Final comments of the Appellant

“Demolition of an existing 2-bed bungalow and erection of a new 4-bedroom bungalow with habitable roof space, including side dormer, raising the ridge of the main roof, roof lights and solar panels.”

Planning Application Reference: 57311/APP/2022/3104

Appeal Reference: APP/R5510/W/23/3318855

DRAWING TITLE	
2207_Proposed Elevation 1/2 rev4	
STATUS	
Planning	
SCALE	1:100 @A3
DRAWN BY	AU
DATE	08/03/2023
CHECKED BY	CHCKD

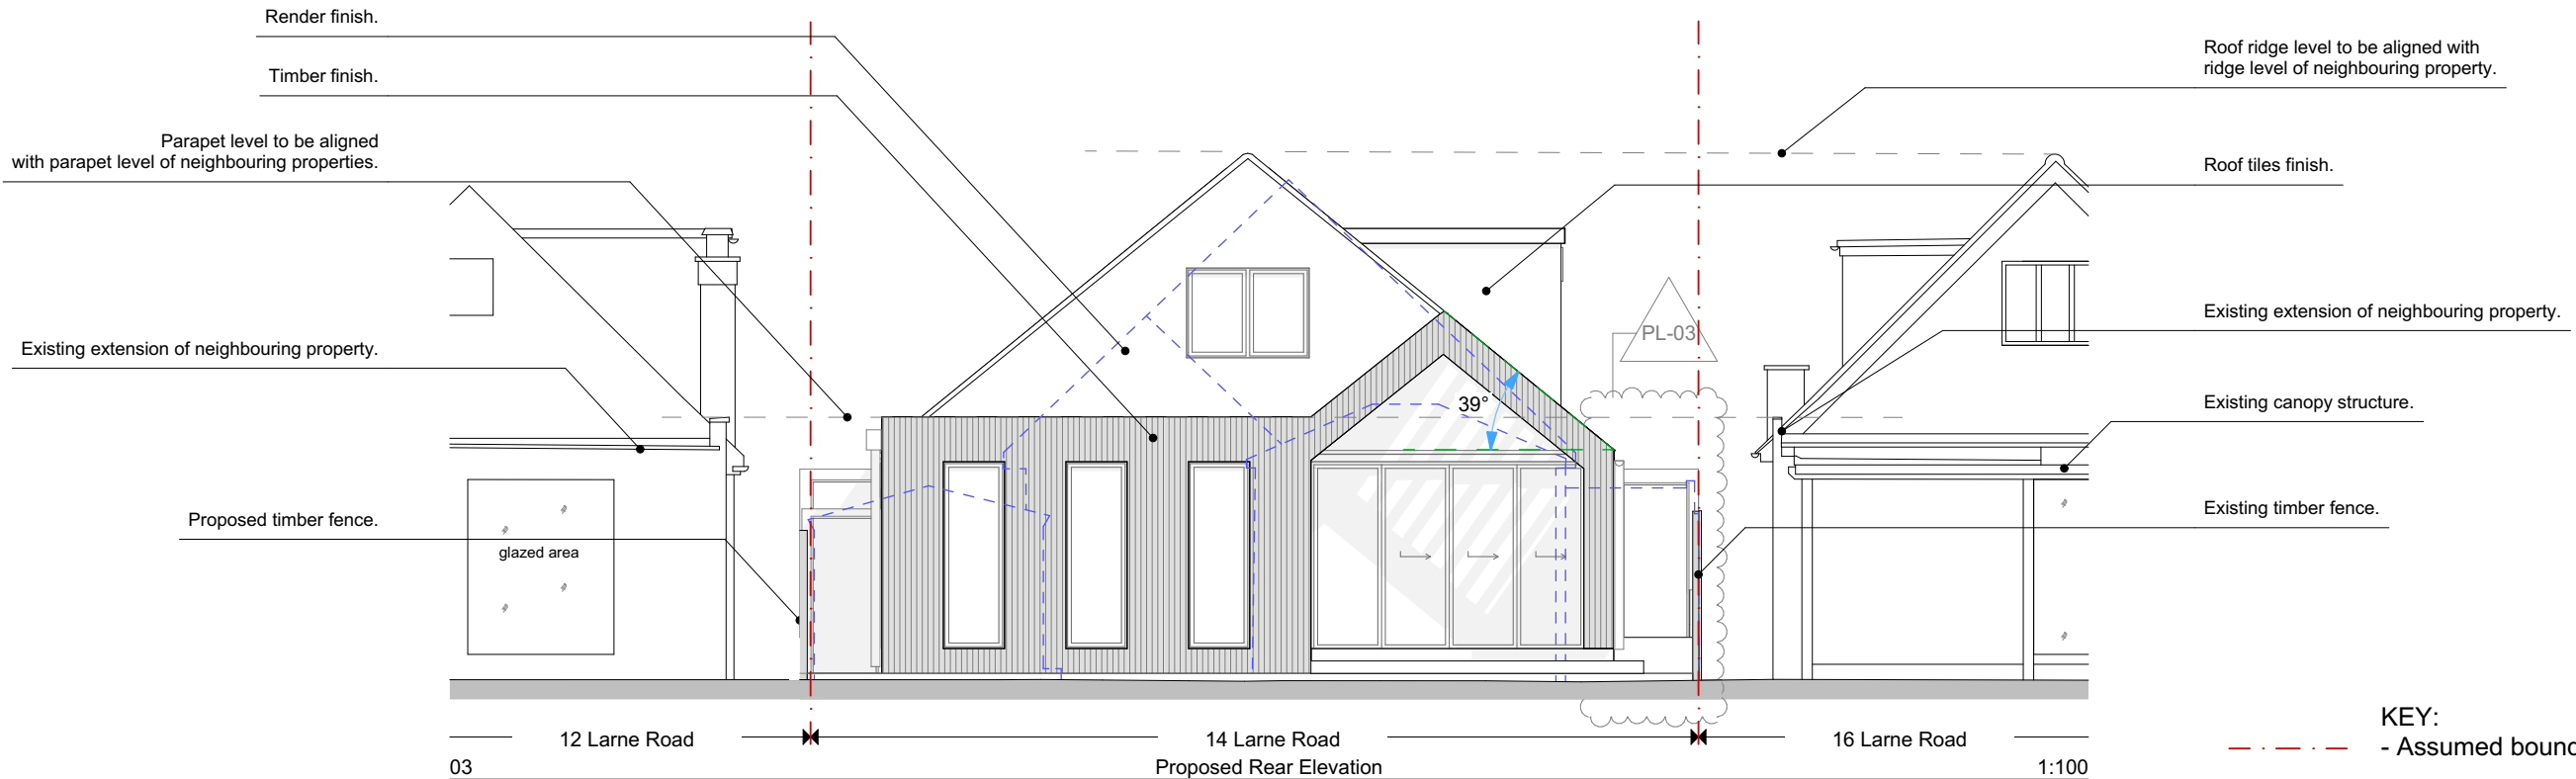
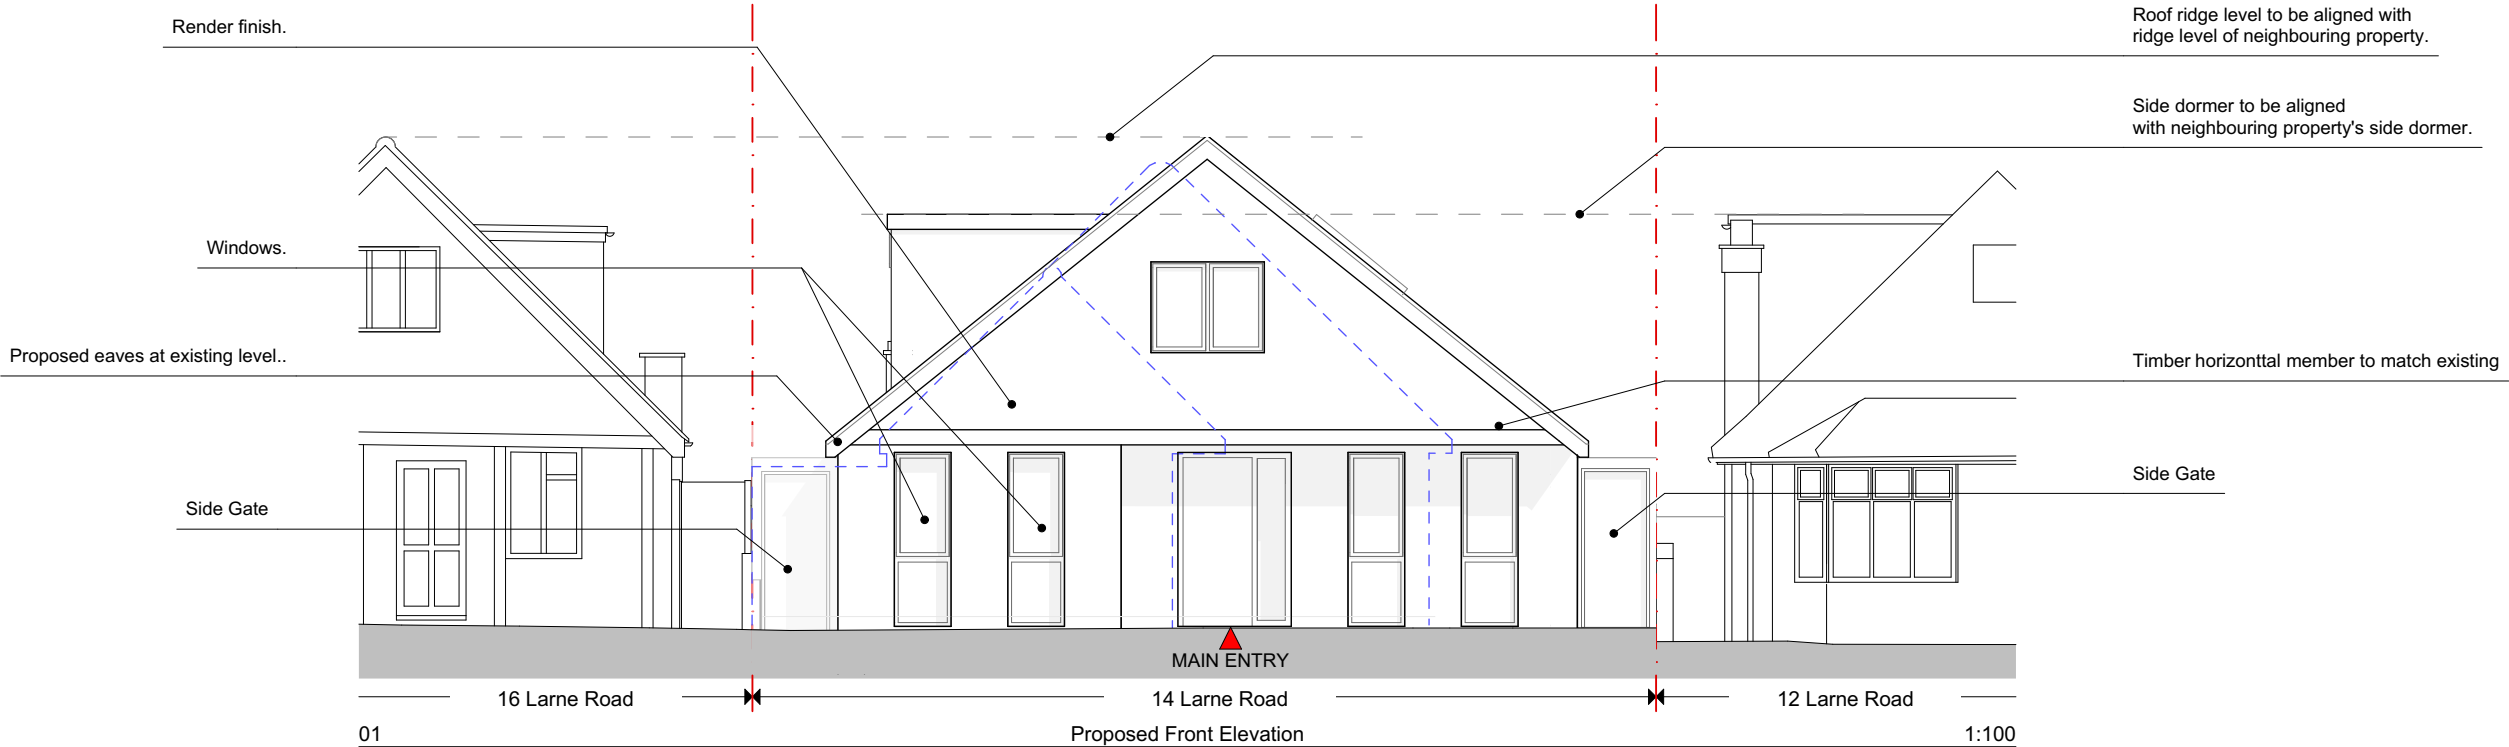
-) Para 1.5 – LPA refers to planning approval being granted to application ref. 57311/APP/2023/322 which is a subsequent application we have submitted following refusal of the appealed application (ref.: 57311/APP/2022/3104). Please note that within our initial statement we refer to the same application as an example of how flexible we could have been with design changes if the planning officer was willing to establish dialog that could lead to a satisfactory conclusion. Following refusal of the first application (which unfortunately was delayed by a month), to avoid further delays, we had no choice but to submit a new application with changes imposed on us by the refusal, to secure planning permission for a design that is almost identical in scale. Several elements have been altered on planning officers request like:

- a) removal of the south side ‘lean to’ element or
 - b) straightening the front wall
 - c) reduction of number of PV solar panels by 50% (which makes the scheme much less energy efficient)

- d) relocation of one rooflight from southern side making it less ‘busy’ (here we would be happy to maintain this change (possibly under condition) to create more space for PV panels if this was preferable).

- We would be happy with most these design alterations, however what we cannot agree with is the removal of the timber cladding and timber shutters which we believe will bring nothing but positive, modern touch to a traditional bungalow house.

-) Para 1.10 – LPA refers to ‘busy appearance’ of the design to include:
- Choice of material - there are only two materials being proposed timber and render as used elsewhere withing the street and the area.

- Angled first floor – as above, this is a very subtle angle which would be hardly visible unless one stands close by.
 - Multiple roof profiles - As mentioned above there is a huge variety of forms and shapes of roofs on the street. This comment should be irrelevant.

- Solar panels – this comment is inappropriate with all houses on the street being allowed to exercise their permitted development rights for solar panels. It is within council’s policies to promote reduction of carbon emissions. We can only expect more solar panels being installed on the street facing roofs in the future. Will we be the only house without the privilege of having access to solar energy? Should this be a privilege or necessity?
-) Para 1.11 – As mentioned above the scale of the proposal has been already approved by the LPA within subsequent planning approval re.: 57311/APP/2023/322. Therefore, this comment should be disregarded.
